Appeal Decision

Appeal Ref: APP/R5510/W/18/3192706

11 Warwick Road, West Drayton UB7 9BT

- The appeal is made under section 78 of the Town and Country Planning Act 1990 against a refusal to grant planning permission.
 - The appeal is made by Mr John Fenton against the decision of the Council of the London Borough of Hillingdon.
 - The application Ref 9746/APP/2017/3485, dated 26 September 2017, was refused by notice dated 7 December 2017.
 - The development proposed is extension to existing offices and the addition of two floors of residential accommodation creating 4 x 1 bedroom apartments.
-

SIDE ELEVATION SOUTH

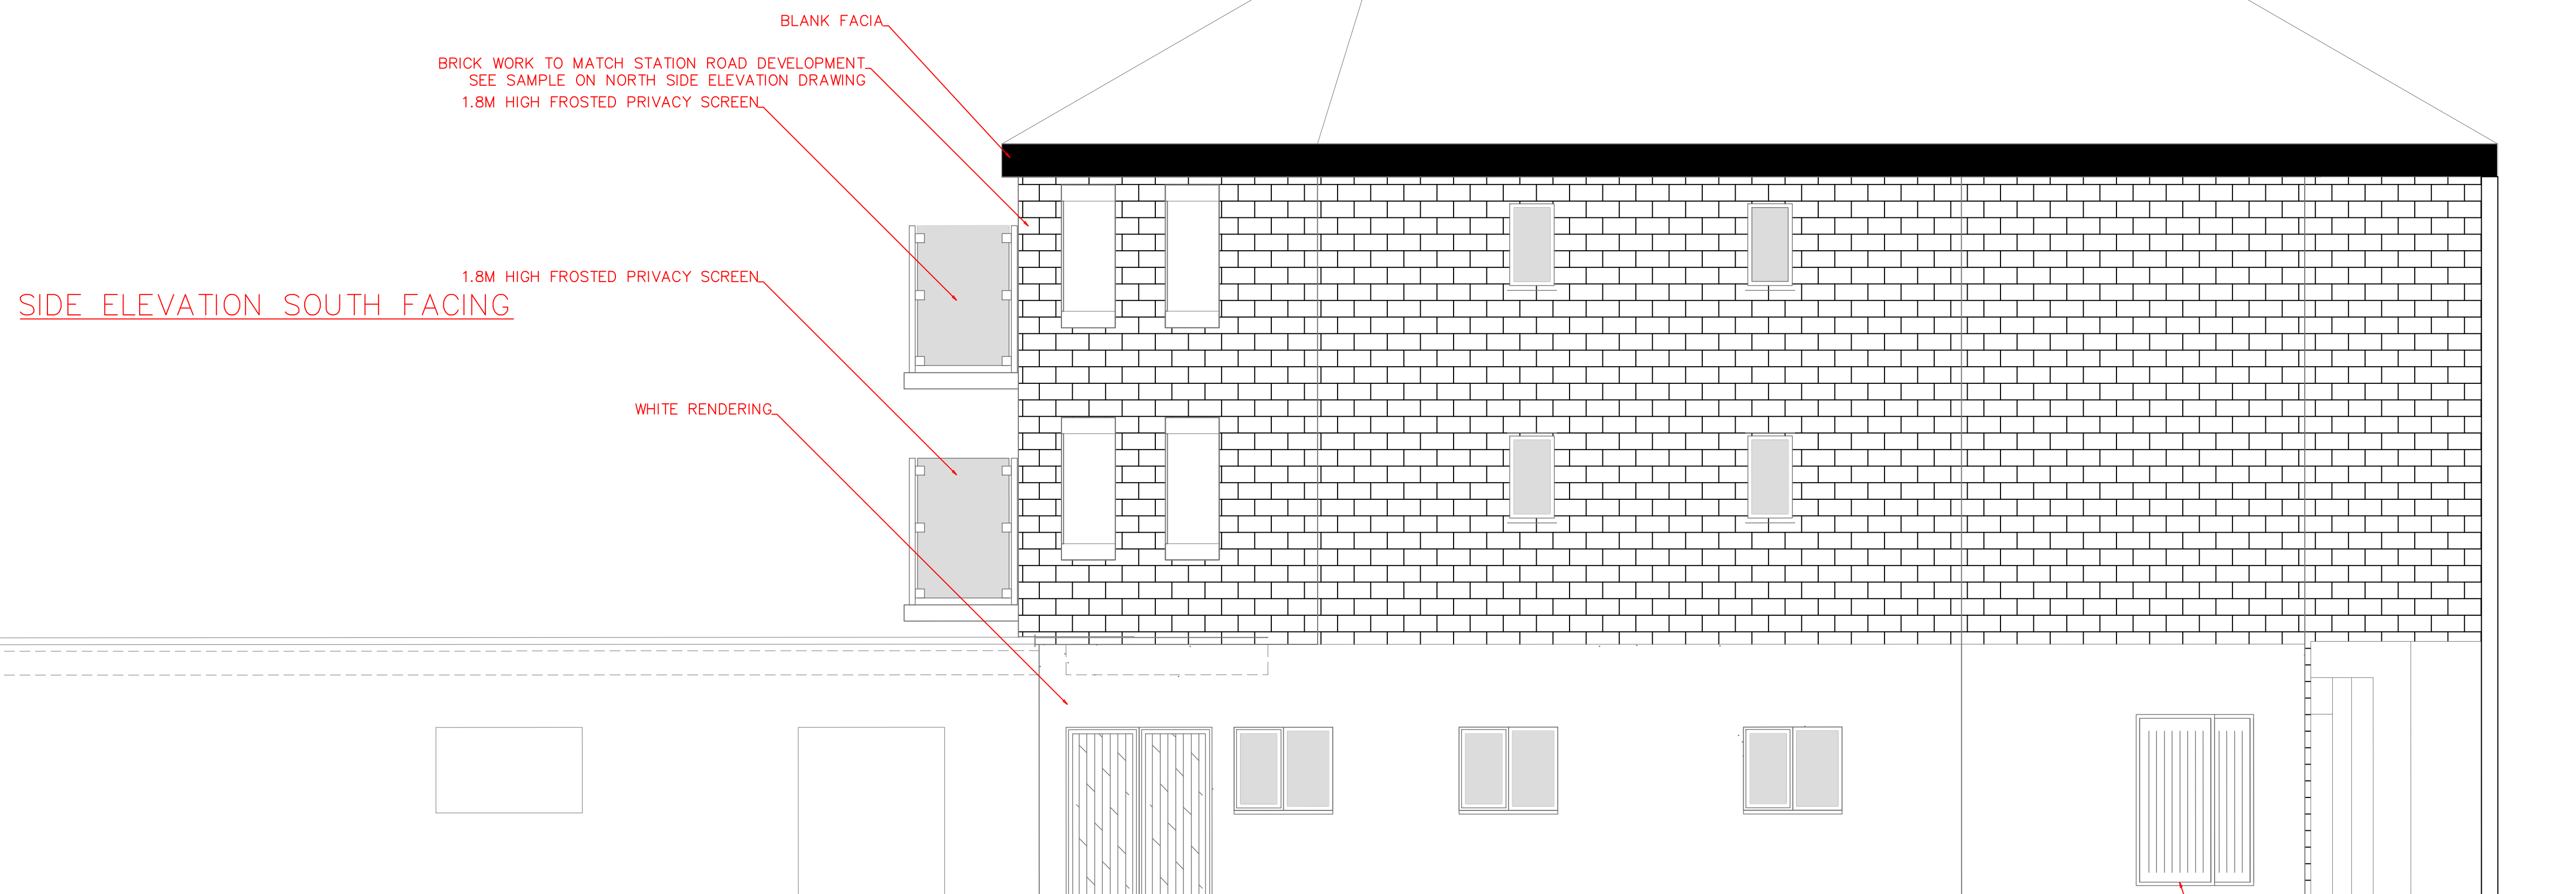
6. This ungainly nature of the development would be exacerbated by the slate grey cladding panels proposed on the south facing elevation. In views from the south, the dark colour of the materials and the lack of detail on this elevation would create a bland and brusque elevation which would contrast starkly with the more articulated elevations seen in the same view.
